From: Charlotte Burrows
Sent: 05 December 2017 15:49
To: 'Willett Technical Services. Andy.Willett'
Subject: RE: Millhouse Croft attention Mrs C Burrows A/195/17/HH

We require a Location plan, this would look similar to the submitted Block plan but would be at a scale of 1:1250.

Code	2017-472	Sheet	2
Drawing	Wall A	Scale	1:50
Material	7.0x13.5	Date	16.08.2017
Designed by	Tuindeco	File	2017-472.dwg

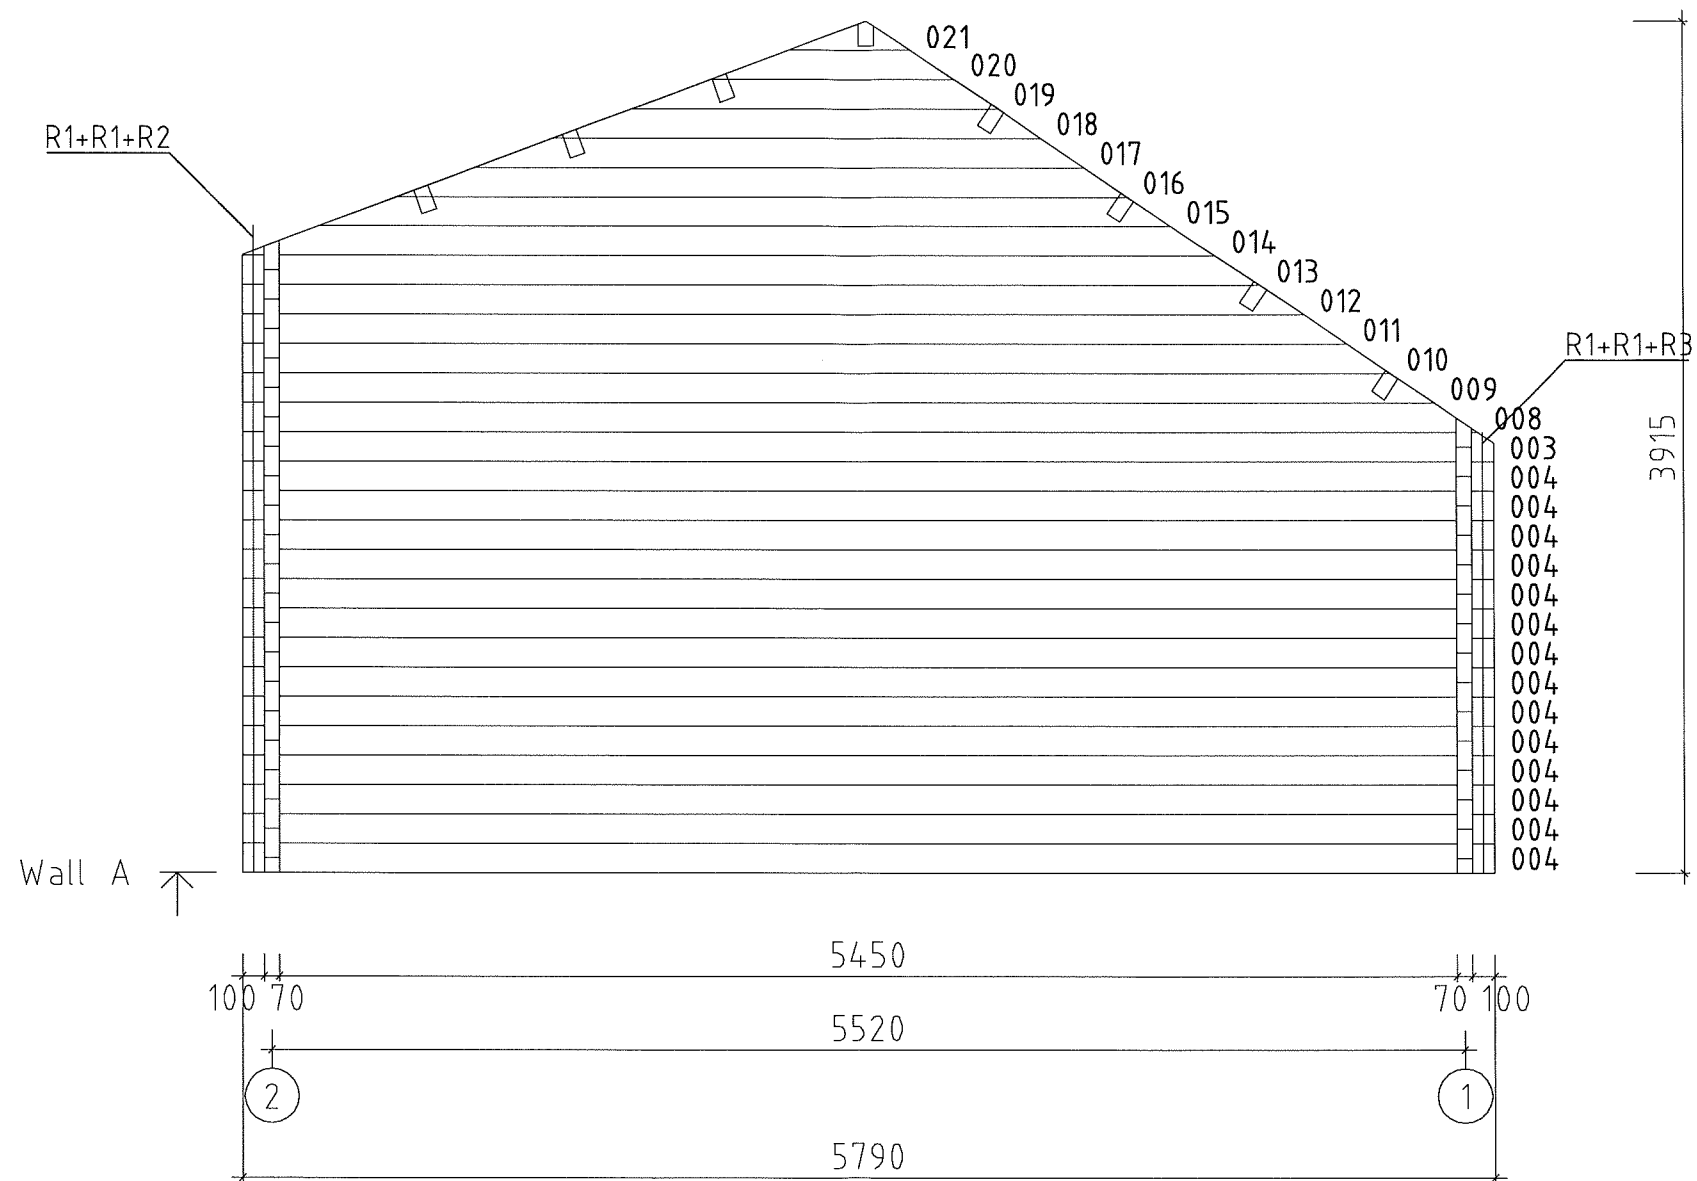
Also, we would ask you label the submitted elevations as to whether they are rear/side/front elevations.

© Crown Copyright 2008. All rights reserved. Licence number 100020449. Plotted Scale - 1:1250

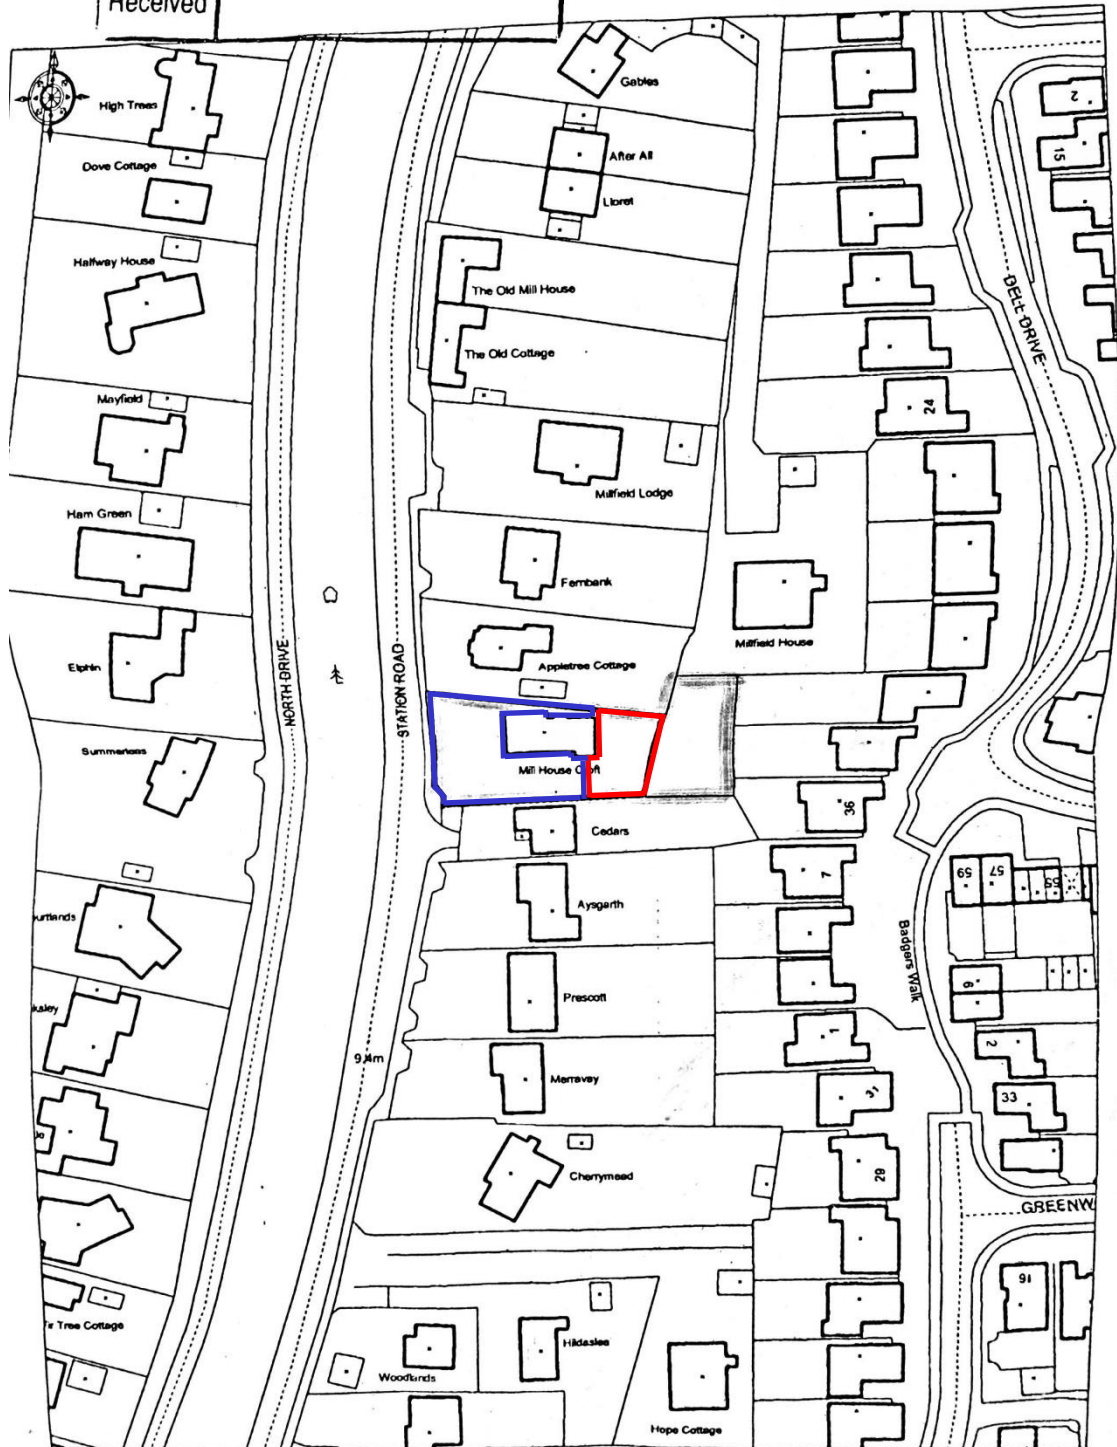
Unfortunately the Location plan you have emailed has come through to us as a jpeg and in Black and white. Could I please therefore ask you resend the Location plan in colour with the red edge going around the site and as a PDF. Unfortunately if the drawing is sent as a jpeg it loses the correct scale it has been printed at.

Hi Charlotte
please find 1:1250 block plan as requested.
